**CITY OF PORTLAND, MAINE
DEVELOPMENT REVIEW APPLICATION
PLANNING DEPARTMENT PROCESSING FORM
ADDENDUM**

498 Island Ave. PEAKS ISLAND

RE: 498 Island Avenue, Peaks Island
(ID# 2003-0261, CBL#090J004)

Thank you for your application for a single-family house at 498 Island Avenue. Upon review, planning department has the following comments:

**BOUNDARY AND TOPOGRAPHIC SURVEY**  
ON  
ISLAND AVENUE, PEAKS ISLAND, PORTLAND, MAINE  
MADE FOR  
**NANCY WRIGHT**

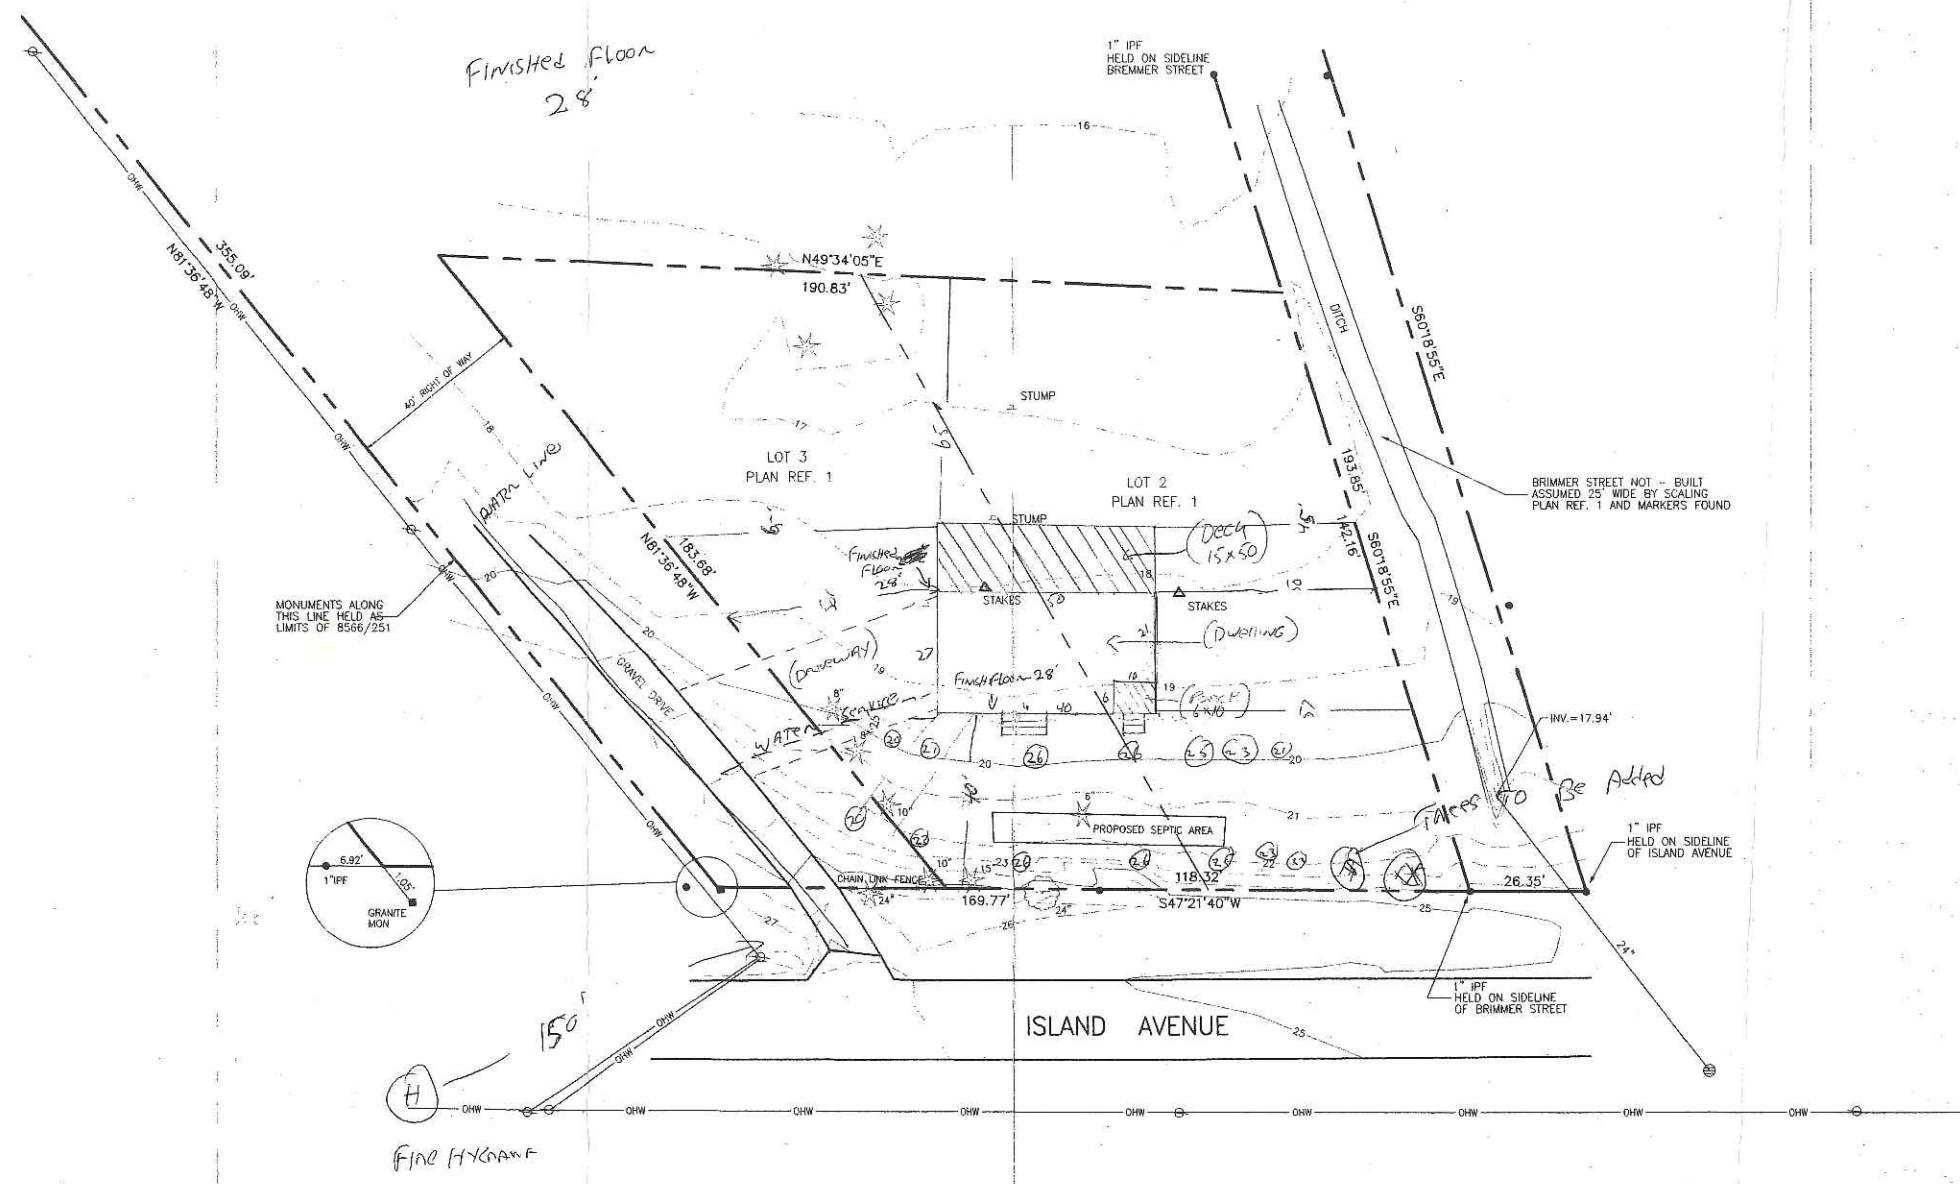
1. Please add any/all proposed changes in grading. Also, add the sill or finish floor elevation.
2. Please add 2 proposed street trees along the Island Avenue frontage of the lot, as required by ordinance for single-family development.
3. Please show the proposed water service/well that will service the new building.
4. Please note the distance of the nearest fire hydrant on the site plan.
